December 30, 2021

**RE: San Roque / La Serena
441 & 457 Coors Blvd NW
Grading & Drainage Plan and Drainage Report
Engineer's Stamp Date: 11/10/21
Hydrology File: J10D049**

**RE: RESPONSE TO HYDROLOGY COMMENTS
SAN ROQUE / LA SERENA
441 & 457 COORS BLVD NW
GRADING & DRAINAGE PLAN AND DRAINAGE REPORT
HYDROLOGY FILE: J10D049**

Overall Grading & Drainage Plan

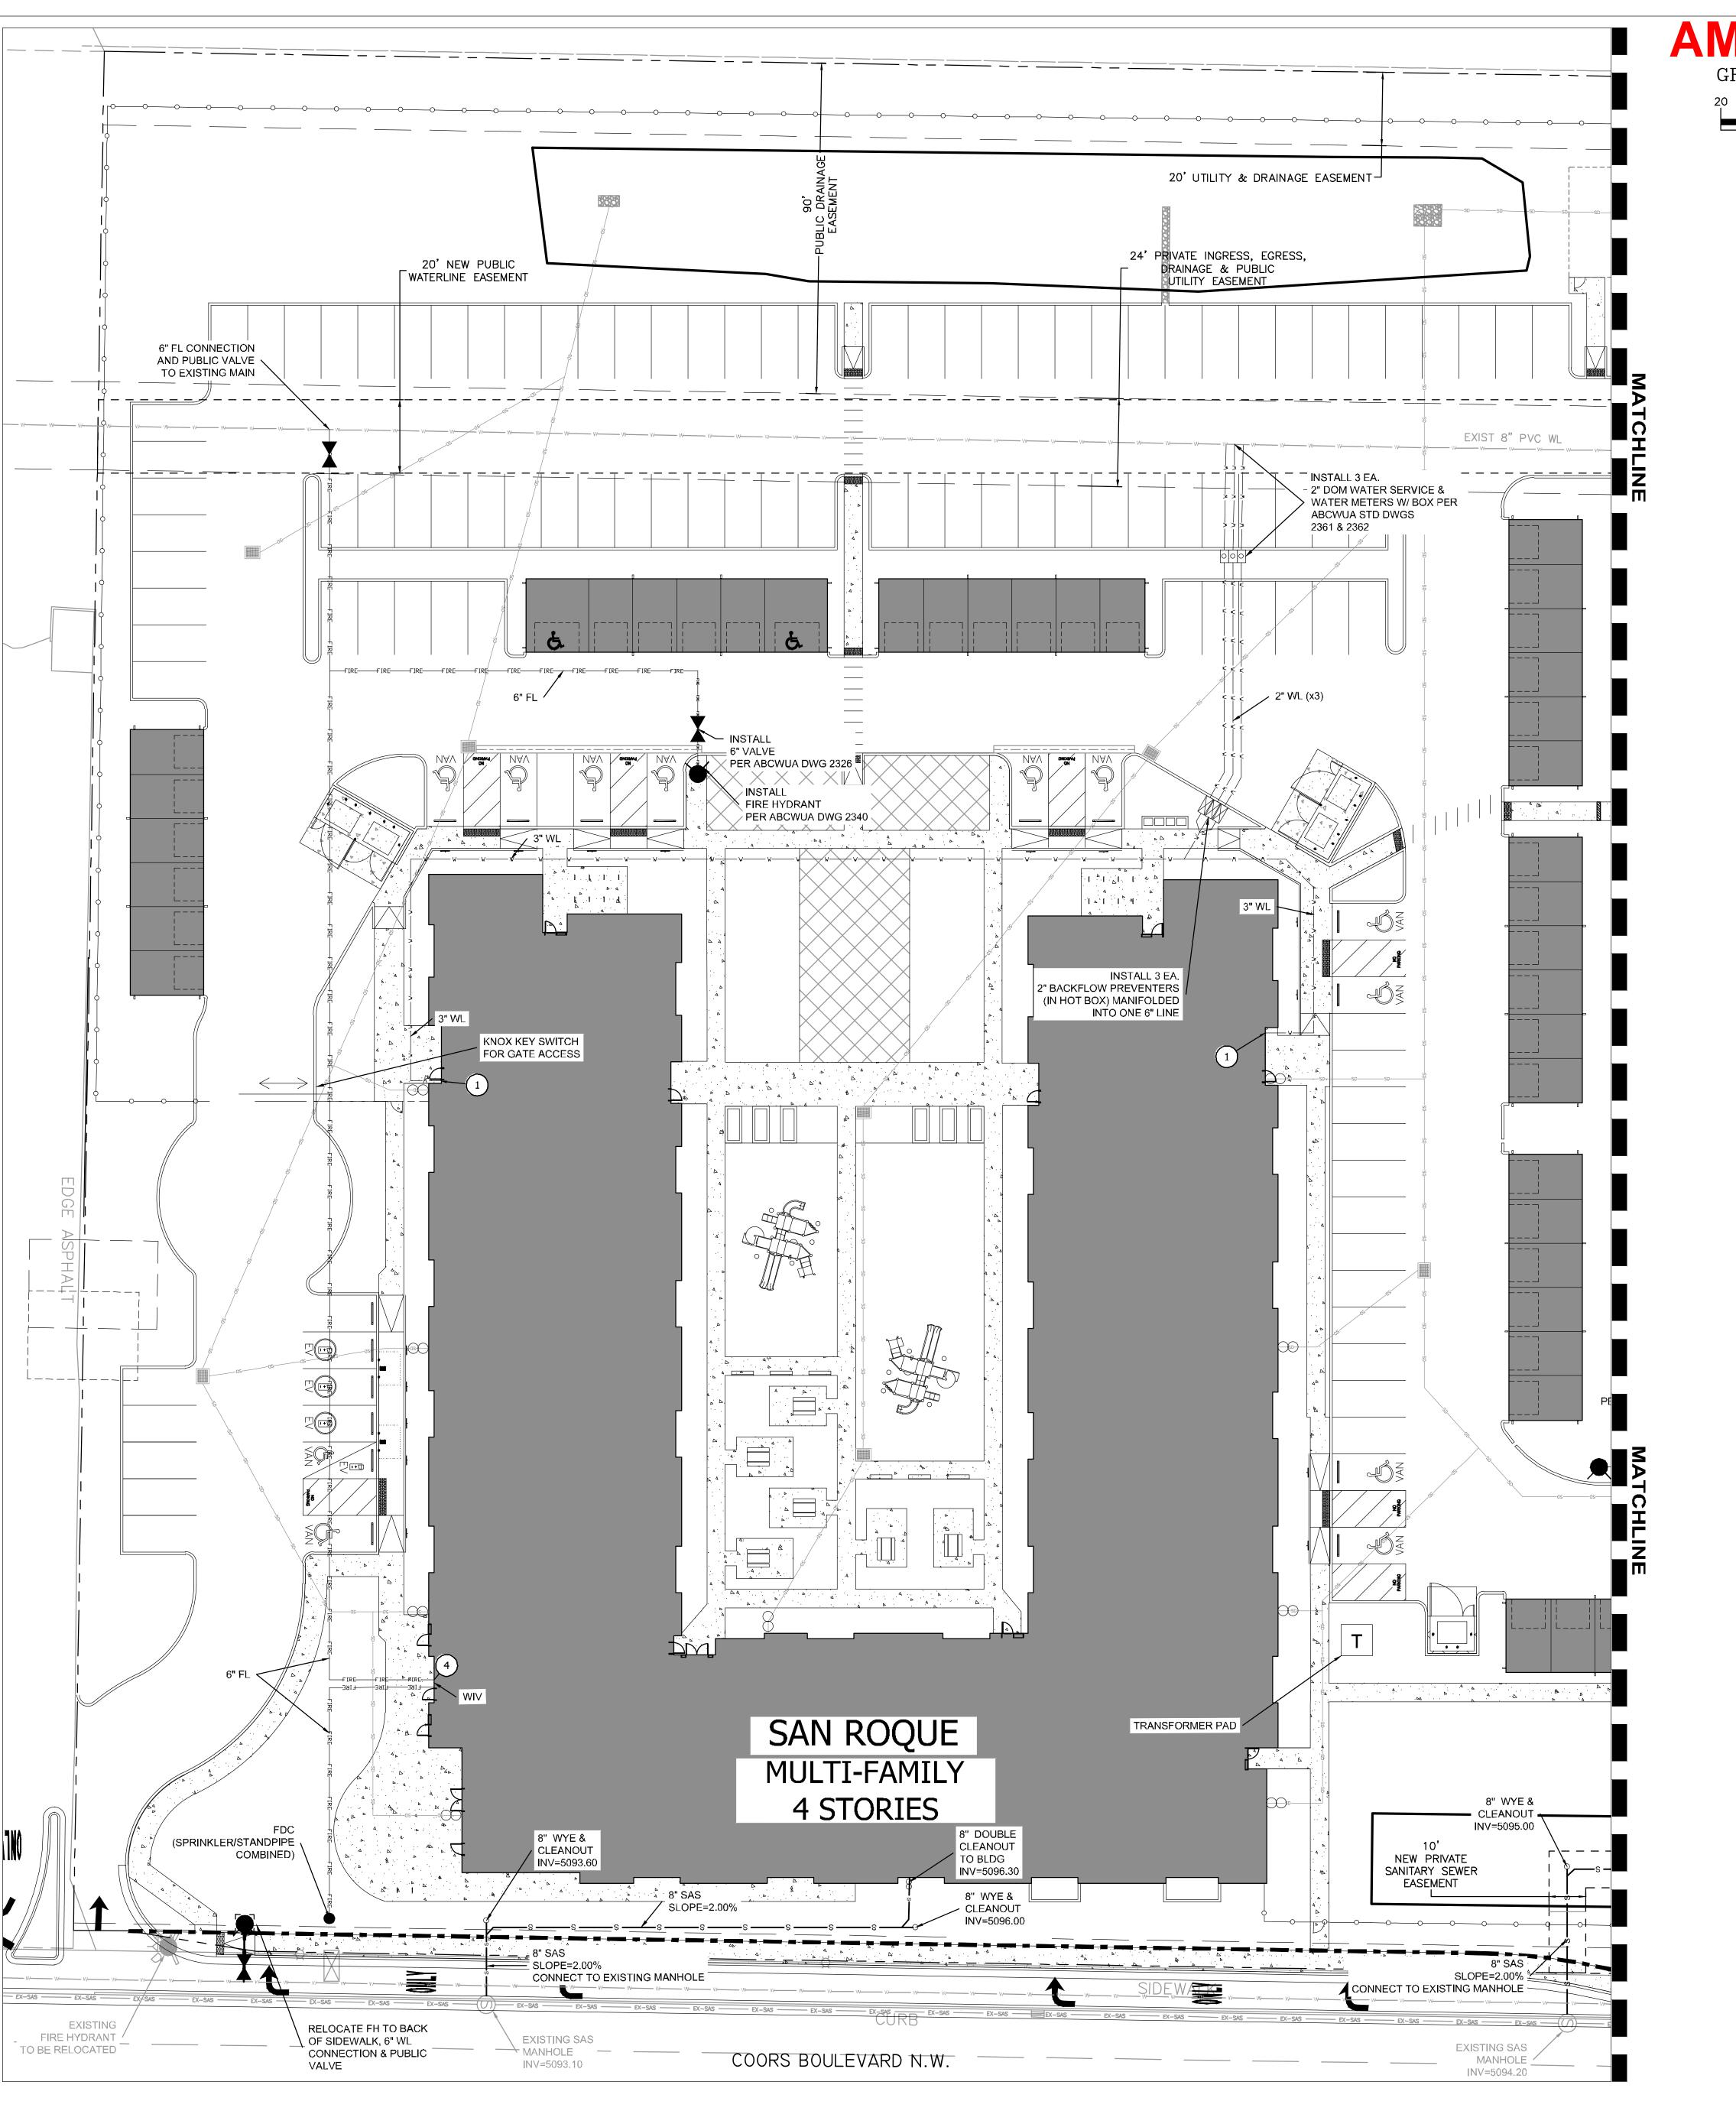
9. Sheet 2.4, 2.5, & 2.6. Please change the title from "Grading Details" to "Grading Enlarged Area". Also on sheet 2.0, please show these areas and label them to go to the correct sheet.

Response: The titles of sheets 2.4, 2.5, and 2.6 now read "Grading Enlarged Area..." with the viewport windows and sheet number references called out on the Overall Grading Plan sheet 2.0.

Grading & Drainage Plan
c2.2

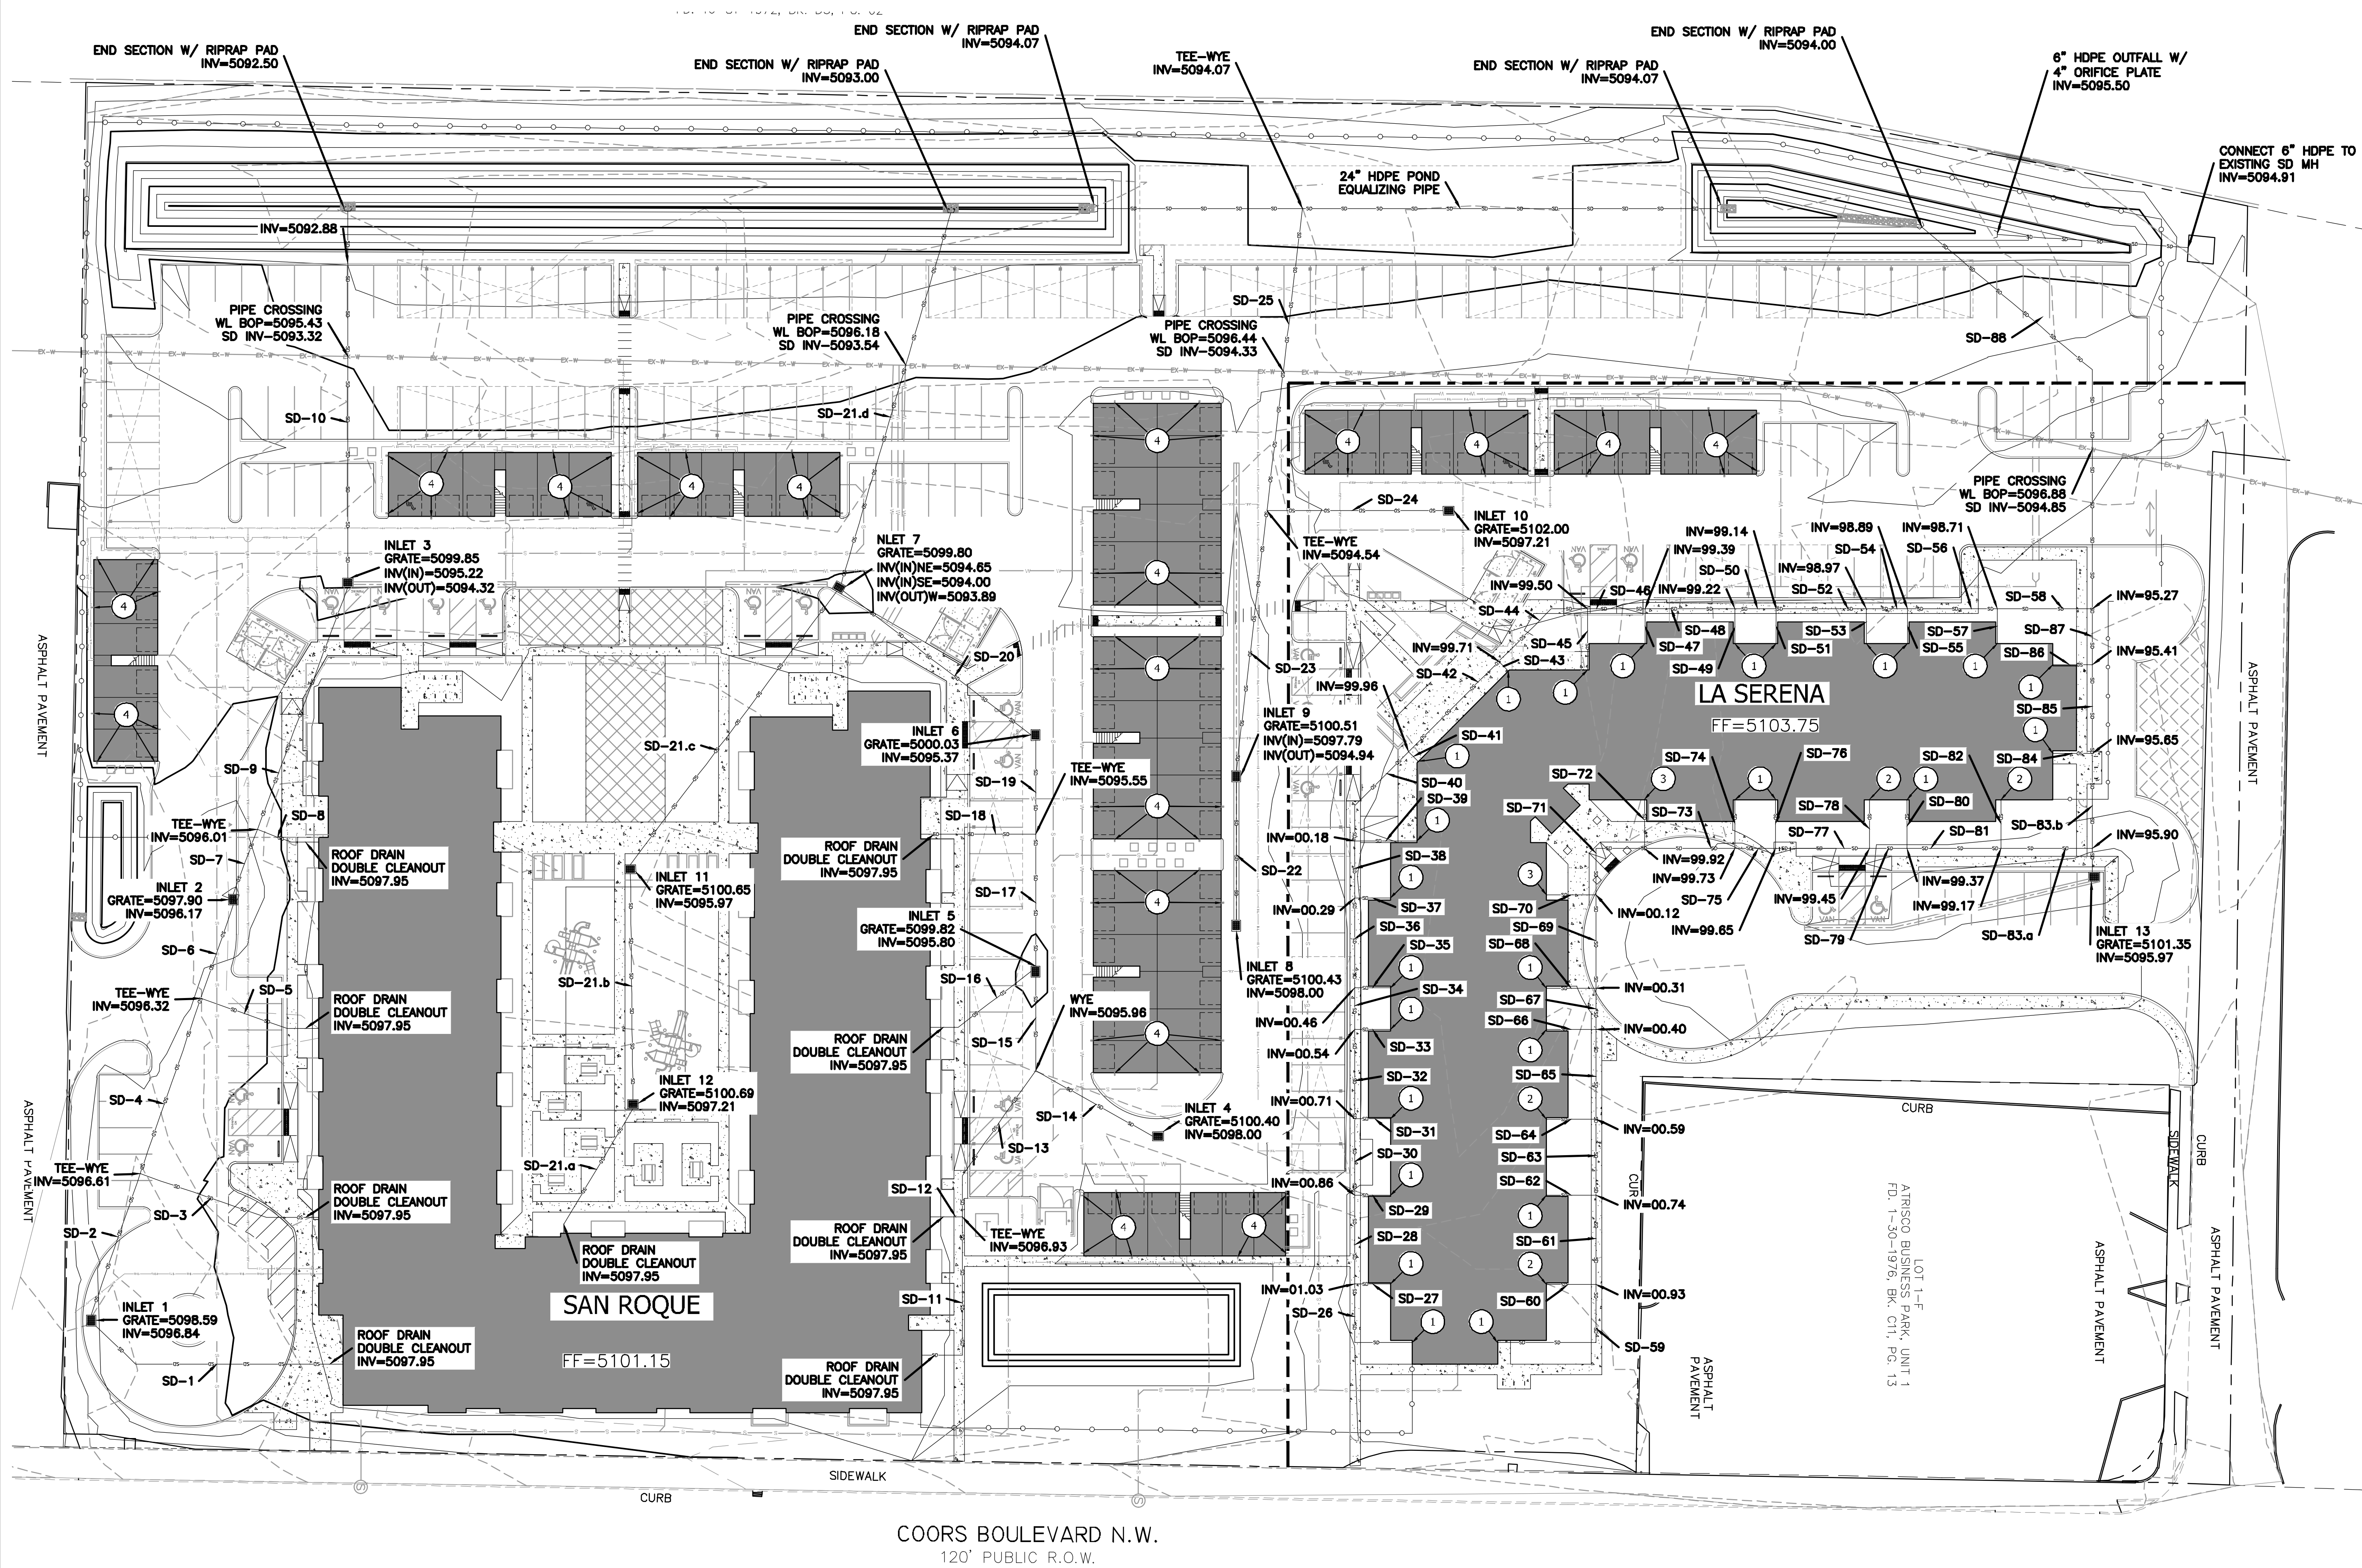
4. Sheet 2.1 & 2.2. Please add what kind of spot elevations these are. (i.e. top of curb, flow line, or top of pavement).

5. Sheet 2.1. & 2.2. Please add the top of grate elevation where there is a grate. It is hard to keep turning to the storm pipe sheet for that information.

7. Sheet 2.2. I believe that the existing edge of asphalt is partially shown but please show the entire edge of it as shown in the photo along with the top of curb for the other side of the adjacent entrance. Is there going to be some additional asphalt from the end of the propose curb radius to the existing curb on the other side of the access drive? If so, then please provide the spot elevations needed to build this.

Response: A spot elevation note has been added to each of sheets 2.1 and 2.2 stating "All spot elevations shown are flowline/bottom of curb unless otherwise noted."

Response: Sheets 2.1 and 2.2 now show top of grate elevations for any inlet that is called out onsite.

Response: Sheet 2.2 now calls out edge of existing asphalt, sawcut line (1' off edge of existing asphalt), and top of pavement elevations. The new pavement is also hatched in gray to show how the new driveways will tie in to the existing asphalt. The existing curb and parking spaces are also shown on the adjacent properties to give a visual point of reference.
